From: Daun Johnson on behalf of Planning.Responses
Sent: 23 October 2013 16:21
To: Planning Scanning; Amanda Scholes
Subject: FW: Planning Consultation on EG/53/13/DOC

Registered: 02-OCT-13
Site Address: Former Brooks Nursery Eastergate PO22 0ED

Description of Works: Application for approval of details reserved by conditions 3, 5, 7, 8, 9, 10, 13, 15, 16, 17, 25, and 28, following a grant of planning permission EG/29/13.

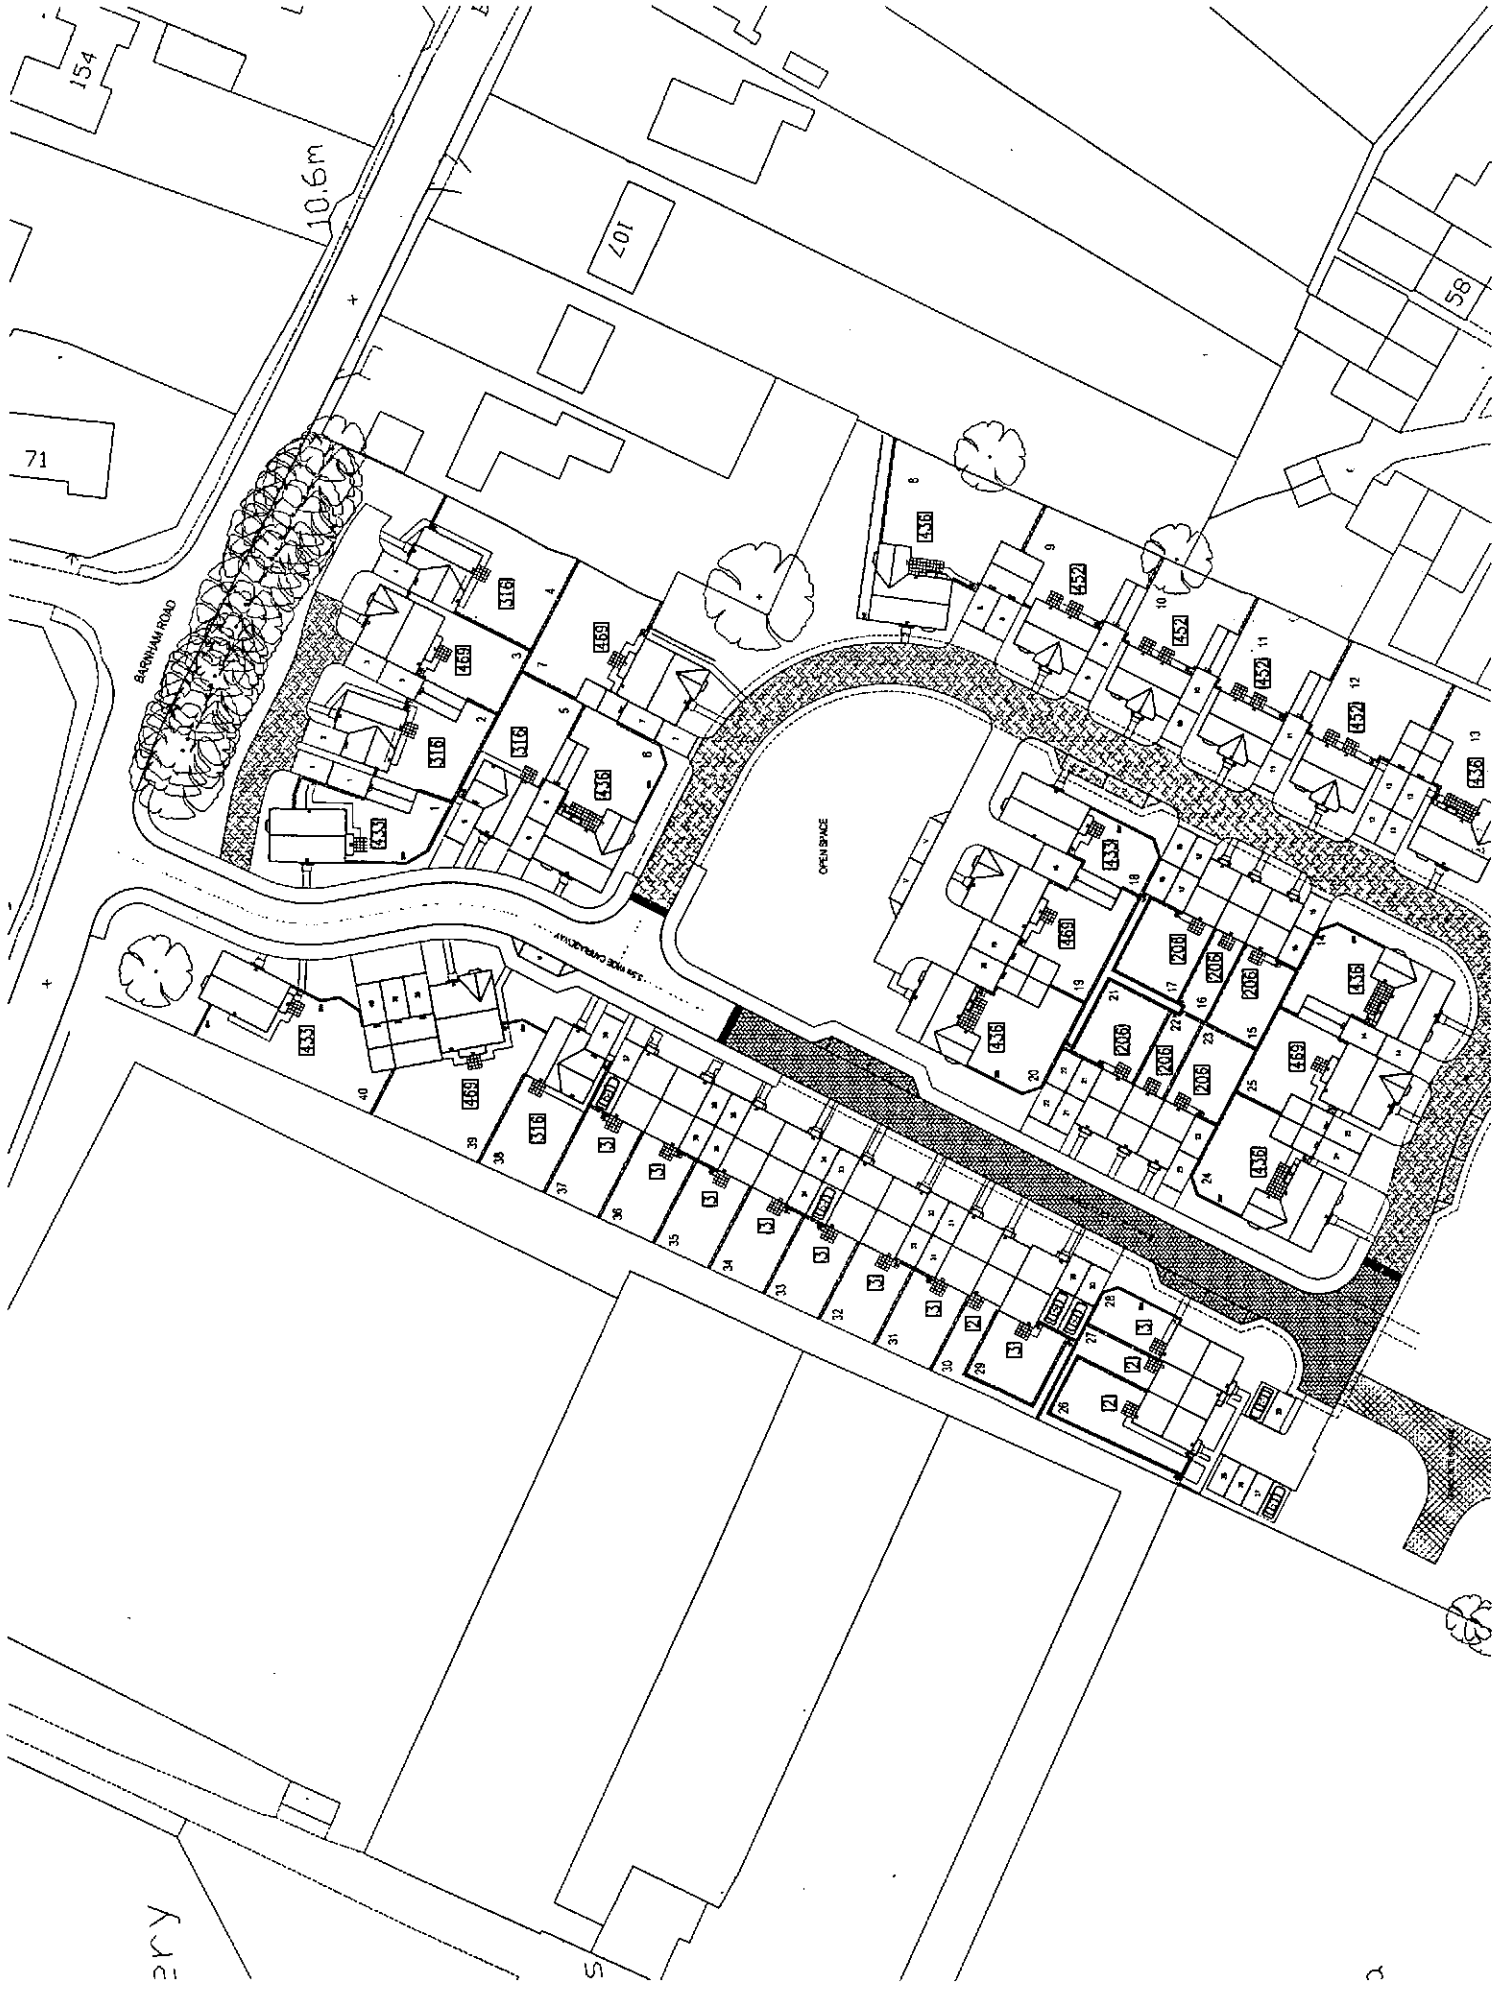
The surface water drainage strategy does not consider the use of infiltration structures, and no extended winter groundwater monitoring or winter percolation testing results have been submitted. Six months of monitoring (October to March) are required before a drainage strategy can be agreed. Infiltration must first be investigated before a discharge to the watercourse can be considered.

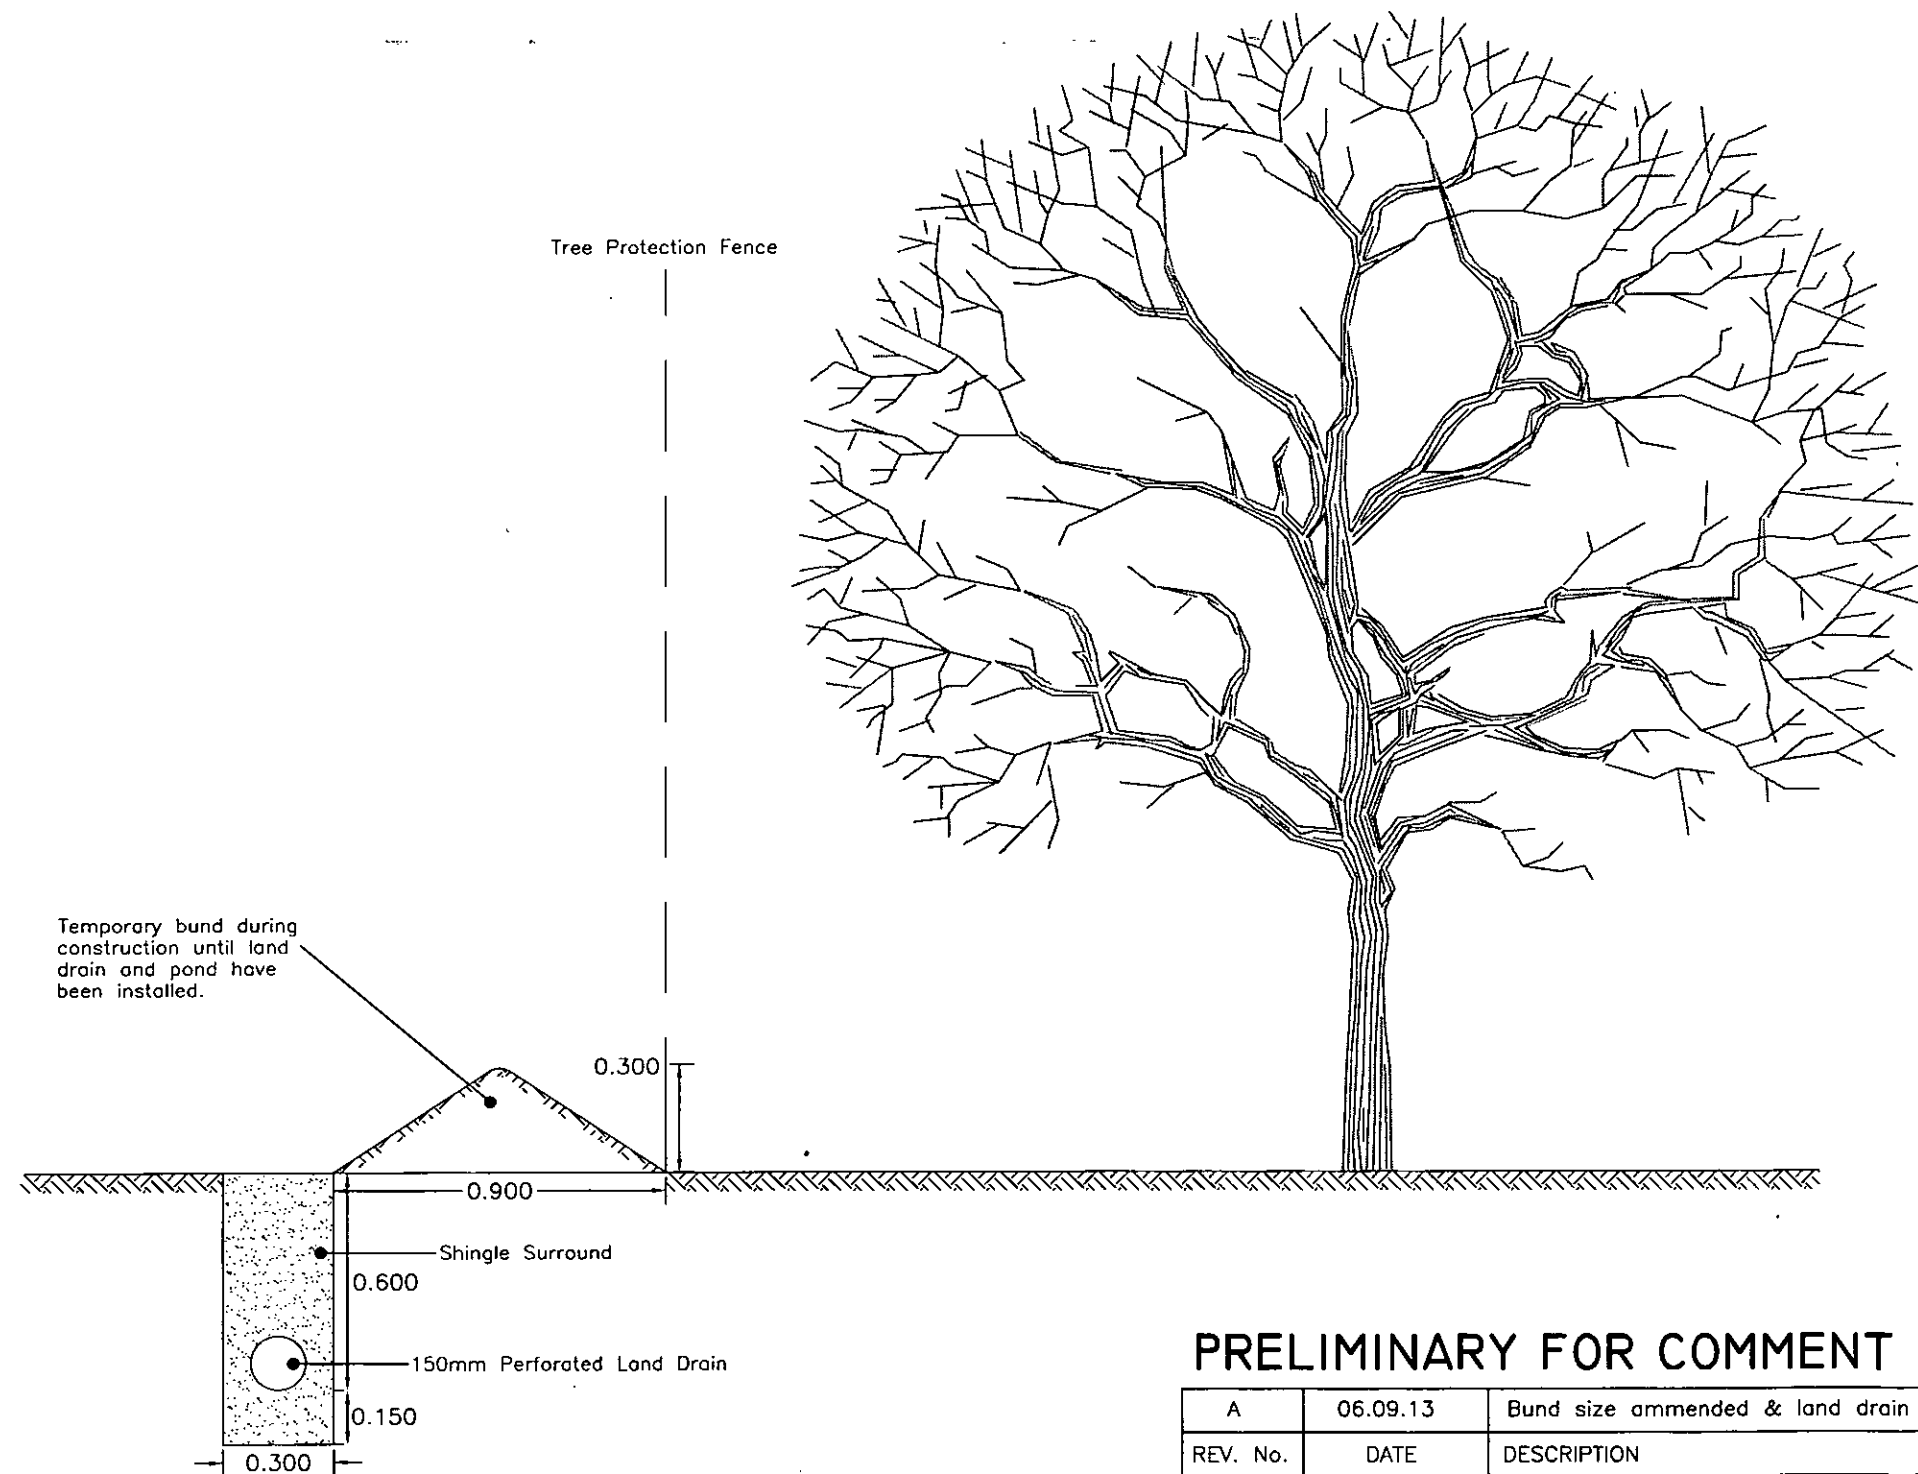
The proposed land drain on the eastern boundary should be contained within a geotextile wrapped 600mm wide trench, and the level of the pipe should be below the lowest ground level (if feasible) of the adjoining property to the east, which suffers groundwater flooding.
